Application for Planning Permission for Works or Extension to a Dwelling

Development: Proposed Detached Garden Room
Location: 1 Greenways Crescent Ferring BN12 5EF

PROPOSED SECTION 1:50

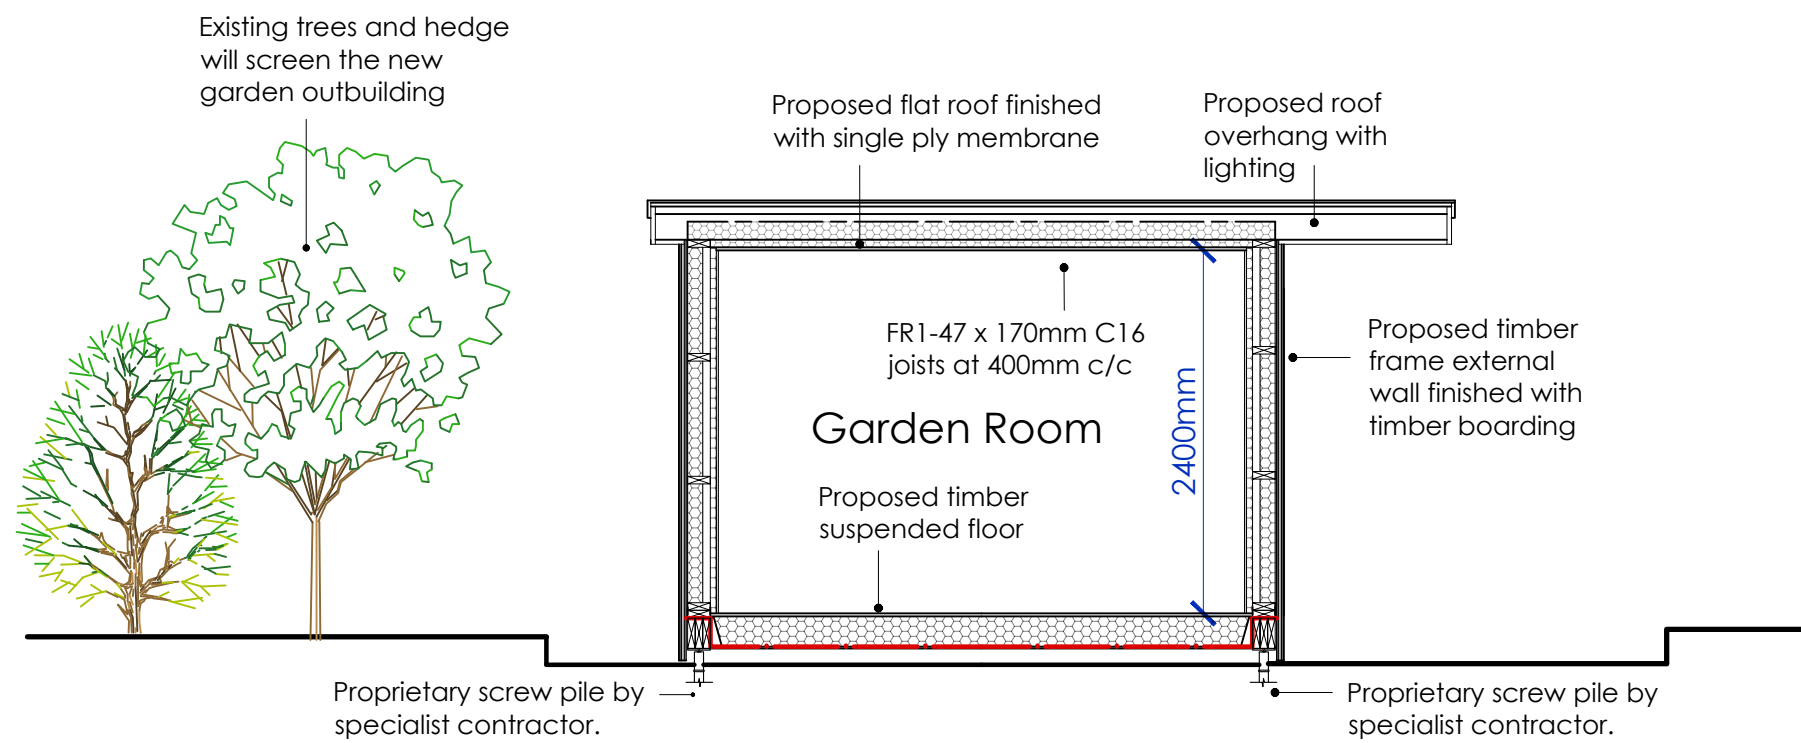
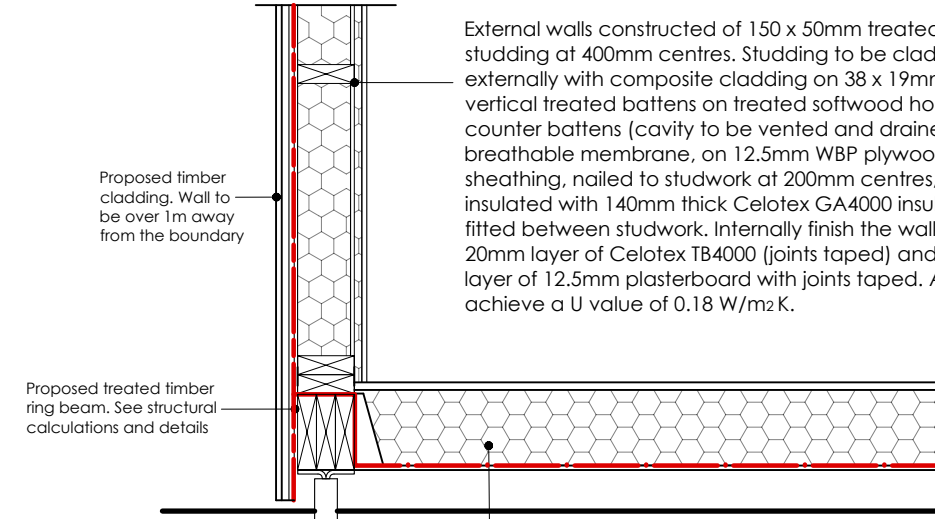
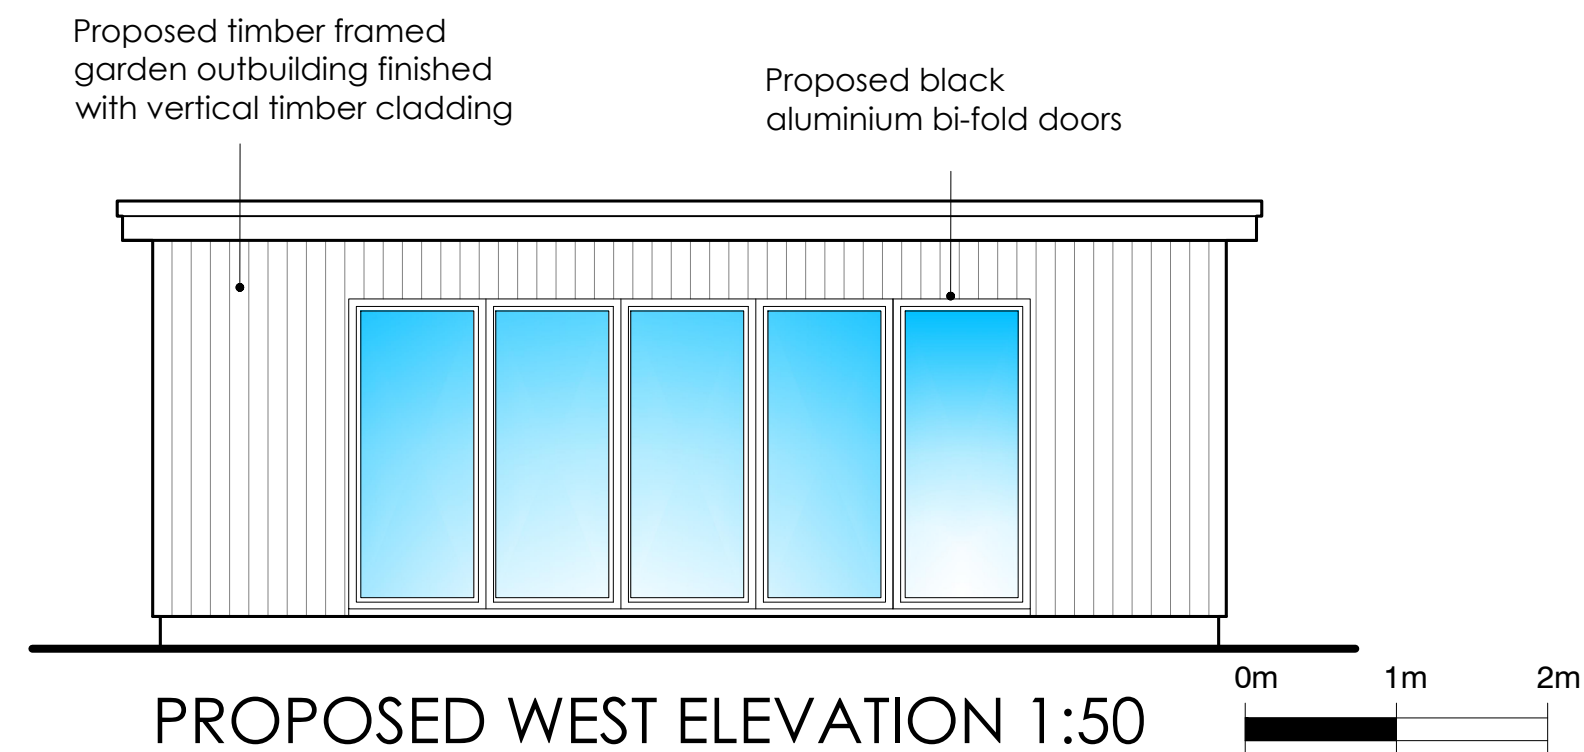
The room labelling is inconsistent between the proposed floor plan and the sections, please review and amend.

LOCATION PLAN 1:1250

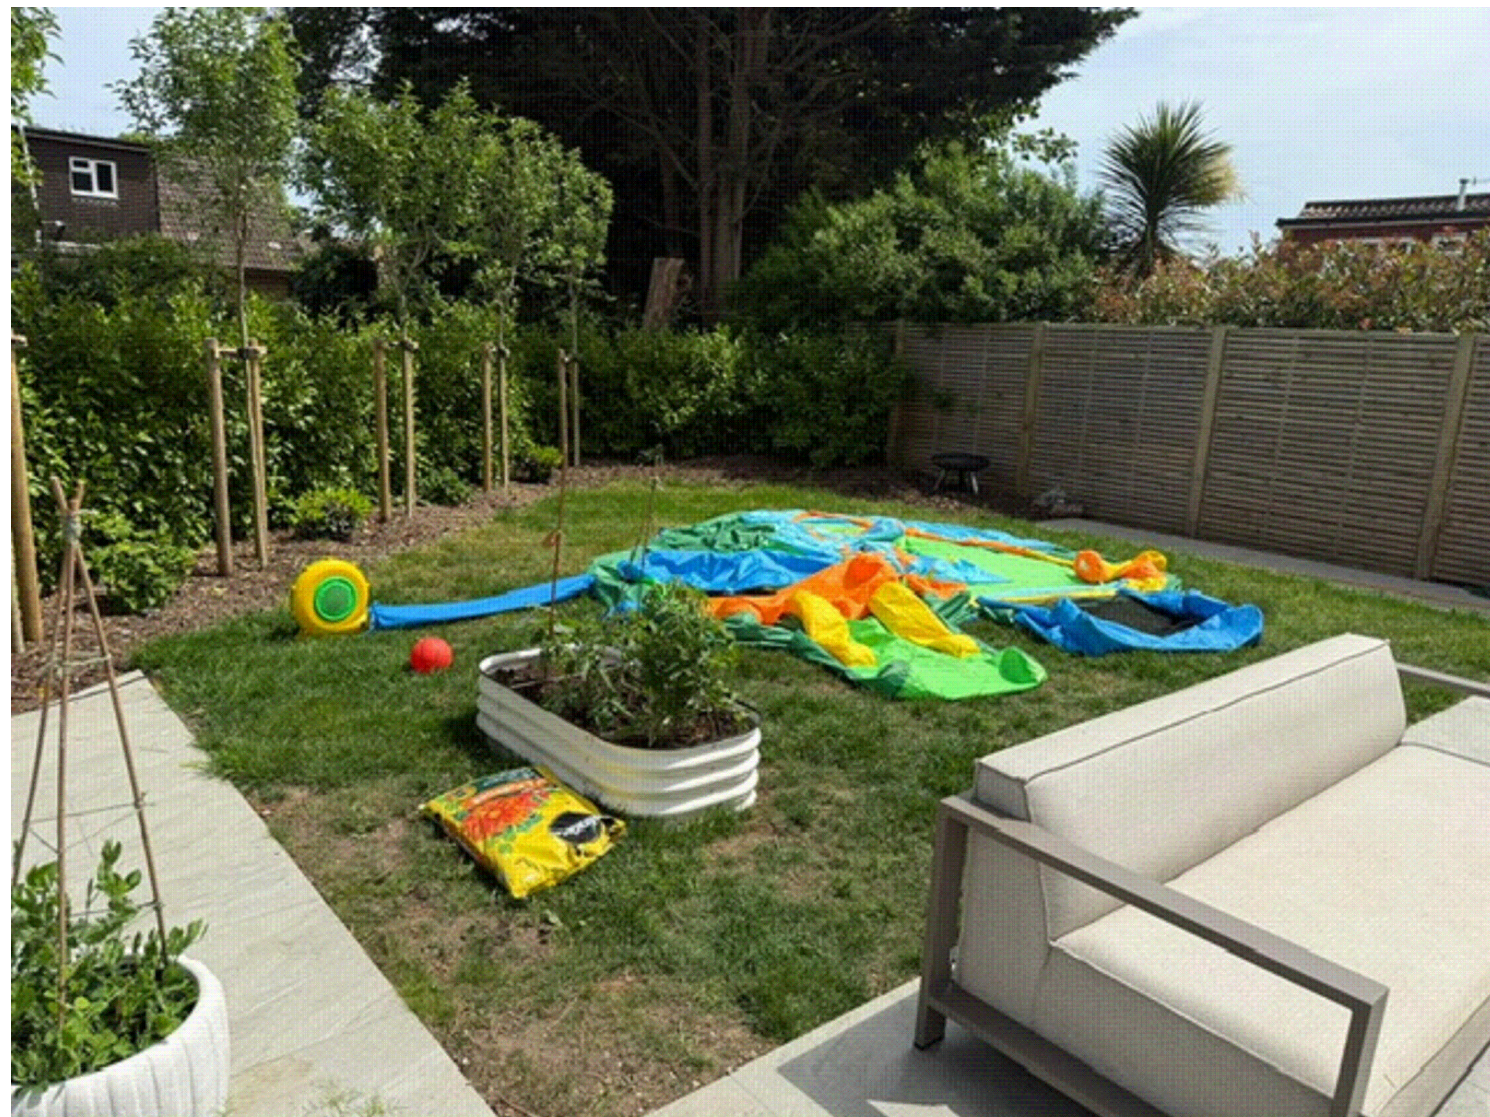
The 1:1250 location plan needs to show the site as existing, please review and amend.
